Kirklees Flood Management & Drainage (Lead Local Flood Authority) – Consultation

Consultation on Application Number: 2018/93416

Address: Dene House, North Road, Kirkburton, Huddersfield, HD8 0RW

Proposal: Demolition of existing unit and erection of replacement unit (within a Conservation Area)

PROPOSED PLANS

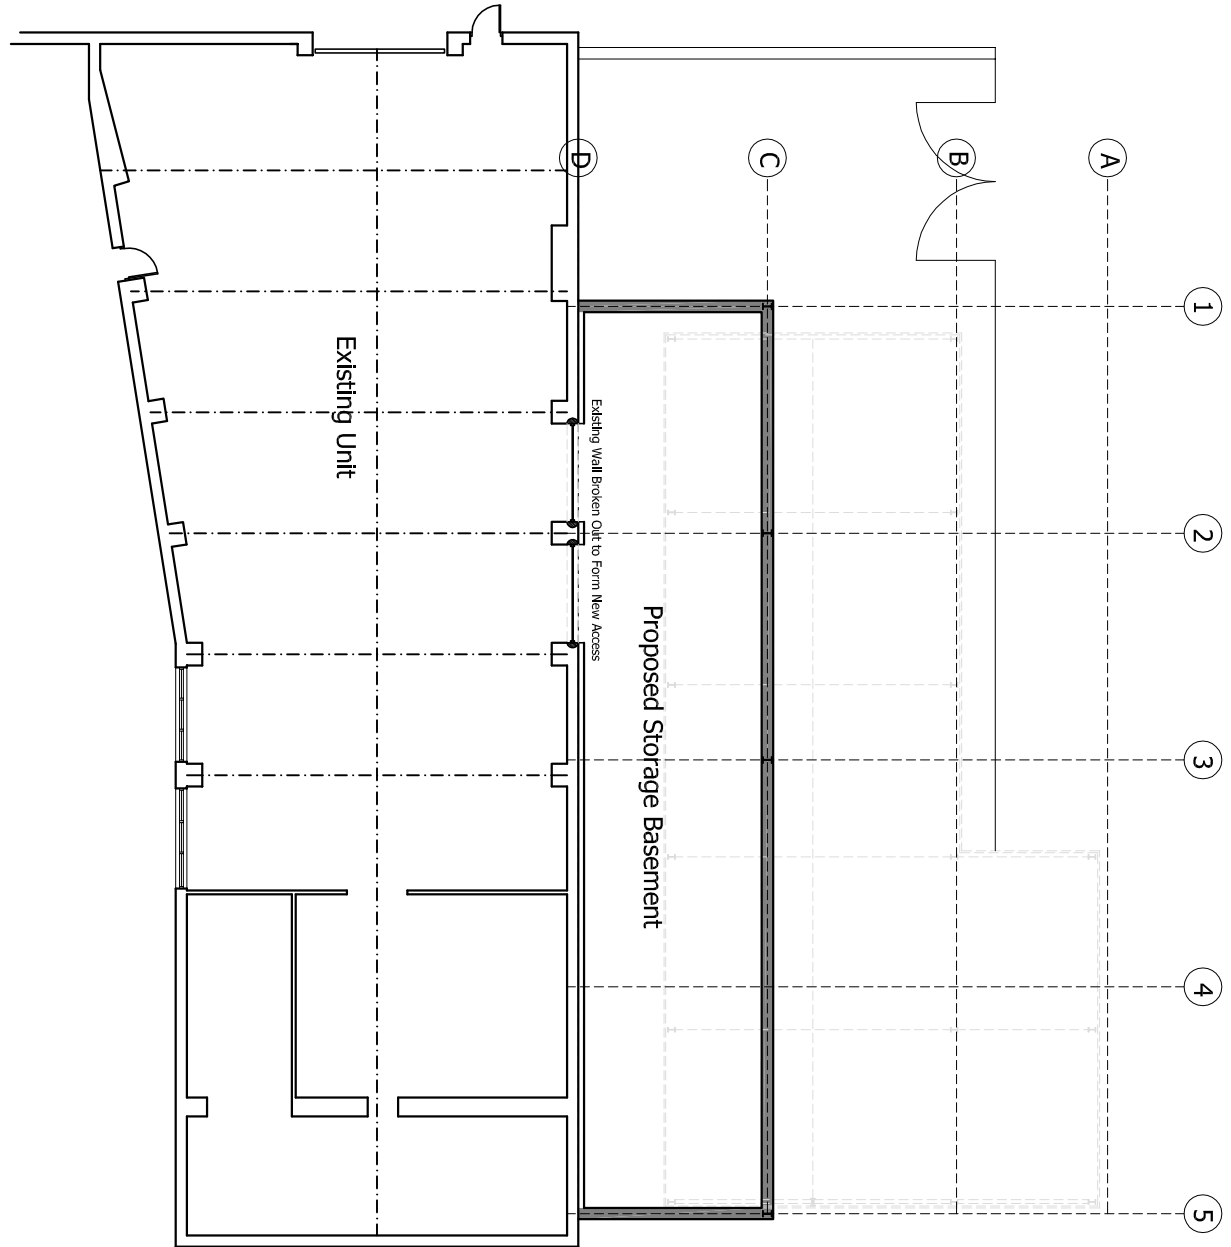
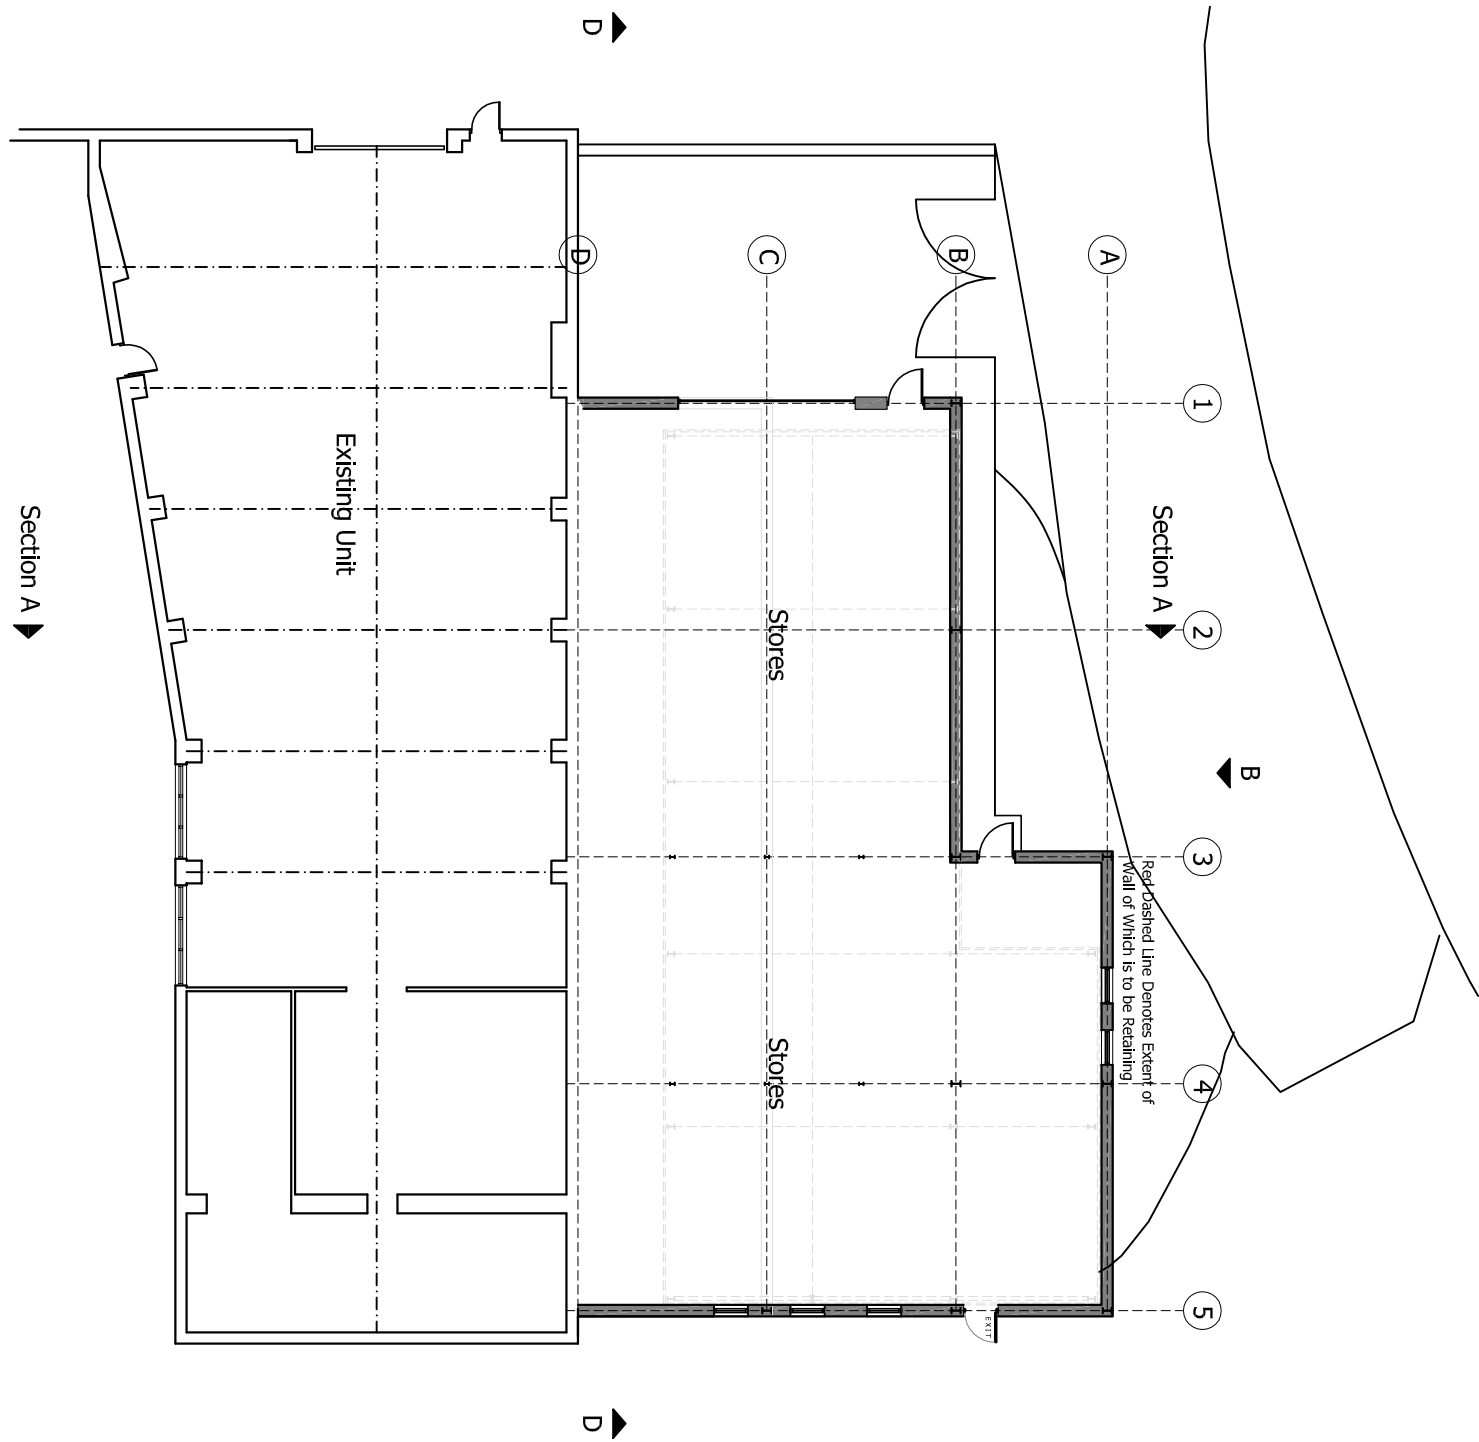
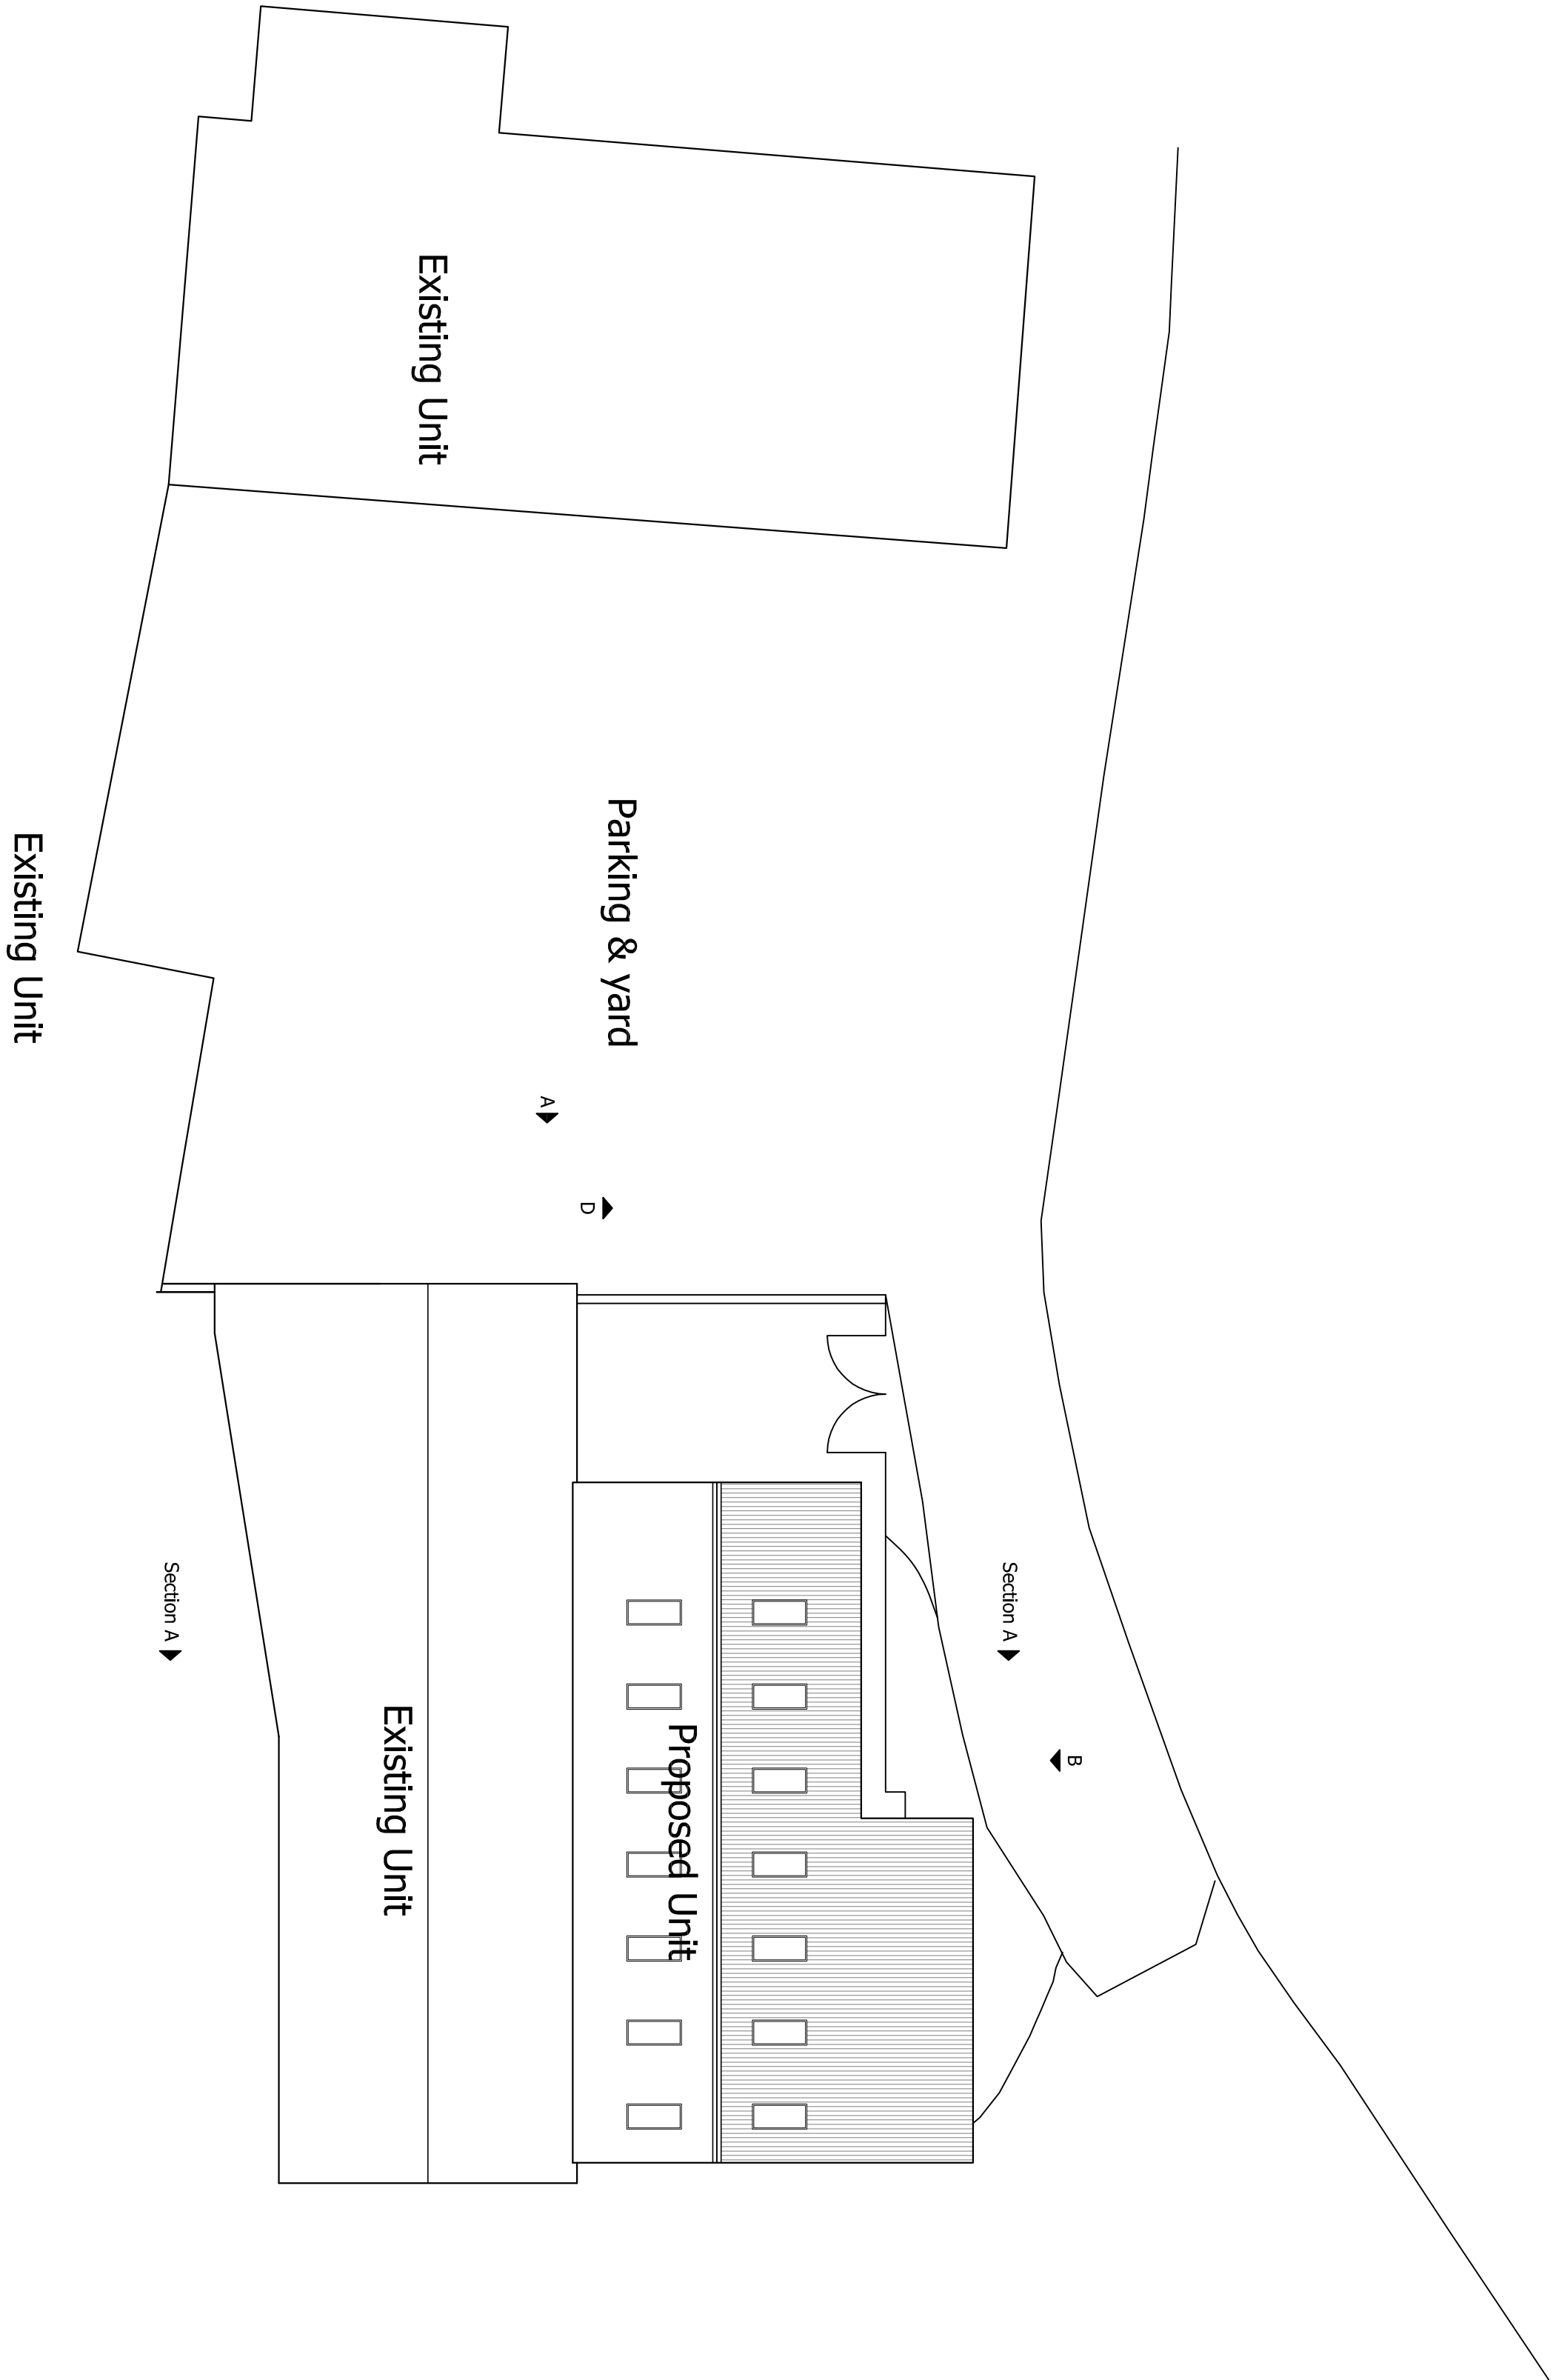
We accept that the location of the building to be demolished is currently shown outside the main river flood zone. However, surface water flood maps show the developed area as inundated, should there be a severe stop that overloads local drainage network, causing overland flow and ponding. Construction of below ground storage represents an increase in risk in terms of likelihood and consequences of flooding.
